# KITITAS COUNTY

## DEPARTMENT OF PUBLIC WORKS

### MEMORANDUM

**TO:** All Staff  
**FROM:** Public Works Plan Review Team  
**DATE:** May 13, 2025  
**SUBJECT:** SP-25-00006 Deatherage

DEATHERAGE SHORT PLAT

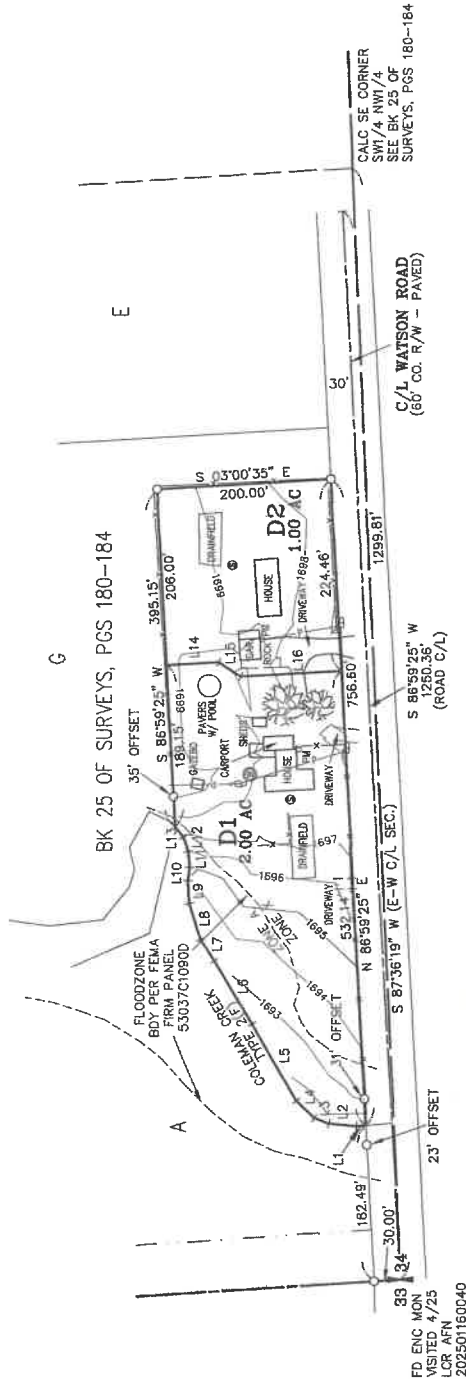
<b>SURVEY</b>	<p>There are no proposed revisions to this prelim Short Plat.</p> <p>For final, the following will need to be addressed:</p> <ol style="list-style-type: none"> <li>1. Property corners to be set</li> <li>2. Basis of bearing to be addressed</li> <li>3. Title report will need to be updated showing the legal owner, as this appears to be absent from the report.</li> <li>4. Fence offsets from property lines to be shown. (JT)</li> </ol>
<b>TRANSPORTATION CONCURRENCY</b>	<p>No transportation concurrency requirement for this project. (KAH)</p>

<b>FLOOD</b>	<p>A portion of parcel# 694934 is within the FEMA identified special flood hazard area (100-year floodplain) zone A. If possible, any future development should occur outside of the floodplain in order to reduce risk and avoid mandatory flood insurance purchase requirements. All activities within the floodplain must be permitted through the floodplain development permit process and follow the regulations within KCC 14.08.</p> <p>In accordance with KCC Chapter 14.08.220, all subdivisions as well as new development shall:</p> <ol style="list-style-type: none"> <li>1. Be consistent with the need to minimize flood damage.</li> <li>2. Have public utilities and facilities such as sewer, gas, electrical, and water systems located and constructed to minimize flood damage.</li> <li>3. Have adequate drainage provided to reduce exposure to flood damage.</li> <li>4. Where base flood elevation data has not been provided or is not available from another authoritative source, it shall be generated for subdivision proposals and other proposed developments containing greater than 50 lots or 5 acres (whichever is lesser) and shall be included as part of the application and shall be noted on the final mylar.</li> <li>5. All subdivisions shall show on the face of both the preliminary and final plat, for either short or long plats, the boundary of the 100-year floodplain and floodway.</li> </ol> <p><b>Since the parcel is located in zone A, KCC 14.08.220(4) is applicable.</b> Please contact the Floodplain Administrator at 509-962-7523 for assistance. (SC)</p>
